Our Ref: AL/16/26/NMA

Non material amendment following the grant of AL/143/24/RES relating to paths north of Plots 26 & 27 and east of Plots 27-16, to reduce the width to 2m for pedestrian use, associated with the delivery of a 2m footway along Lidsey Road (path around Plot 15 provided as 3m).
Amendment to path north of pumping station and east of sub-station, to increase width to 3m for shared pedestrian/cycle use (on opposite side of spine road to Plots 43-48), with directional signage for cyclists and amendment to materials layout, to enable contrasting brick detailing (use of orange feature brick on red brick plots and red feature brick on orange brick plots).

Land Adjacent to Woodgate Nurseries Lidsey Road Aldingbourne PO20 3SU

Rev	Description	Date	Drawn	Chk'd
Building Heights Plan - Phase 1				
Project: Ladbroke Road Woodgate				
Client(s): BDW Southampton				
Drawn No:	ST-22-06	Rev:	N	
Scale:	1:500 @ A0	Date:	23/07/2024	
Drawn By:	SW	Checked By:	-

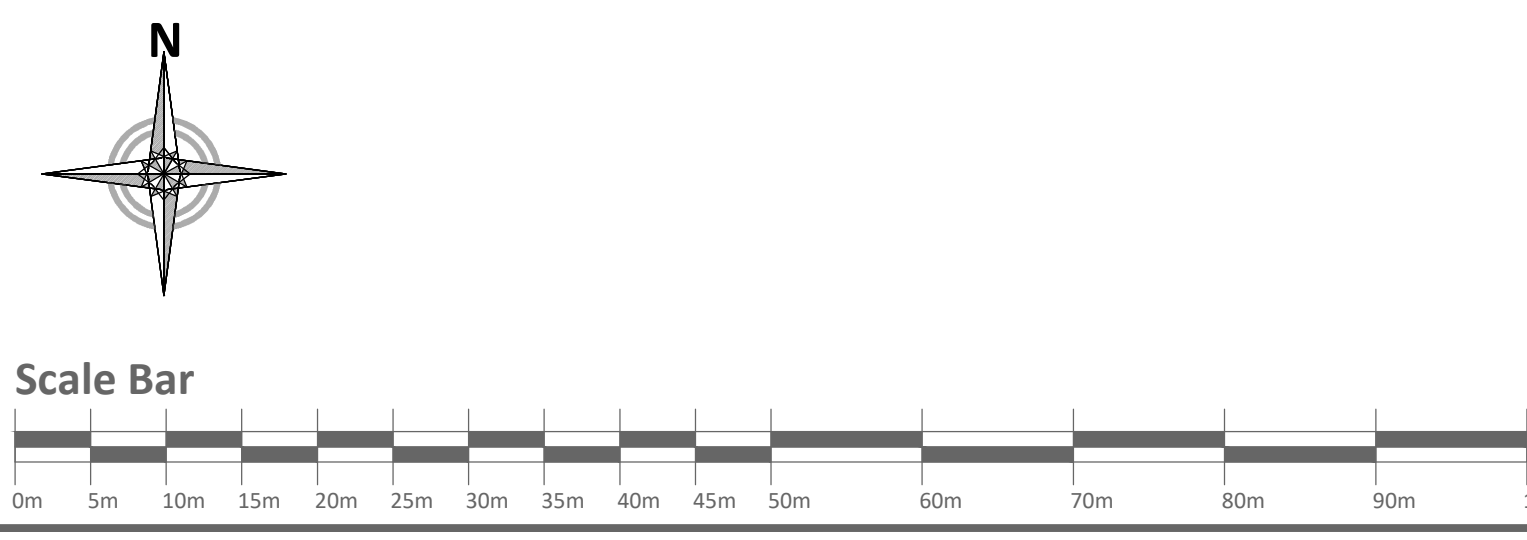
- Amendment to paths north of Plots 26 & 27 and east of Plots 27-16, to reduce the width to 2m for pedestrian use, associated with the delivery of a 2m footway along Lidsey Road.
- Amendment to the path north of the pumping station and east of the sub-station, to increase the width to 3m for shared pedestrian/cycle use (on opposite side of spine road to plots 43-48), with directional signage for cyclists.
- Amendment to the agreed materials, to enable the use of orange feature brick on red brick plots and red feature brick on orange brick plots.

- ST-22-01 Rev. X - Planning Layout.
- ST-22-04 Rev. N - Housing Mix Plan.
- ST-22-05 Rev. P - Affordable Housing Plan.
- ST-22-06 Rev. N - Building Heights Plan.
- ST-22-08 Rev. N - Boundary Treatments Plan.
- ST-22-09 Rev. P - Materials Plan.
- ST-22-10 Rev. N - Bin & Cycle Storage Plan.
- ST-22-11 Rev. N - Parking Plan.
- ST-22-15 Rev. P - Surface Materials Plan; and
- ST-22-19 Rev. J - EV Charging Plan.
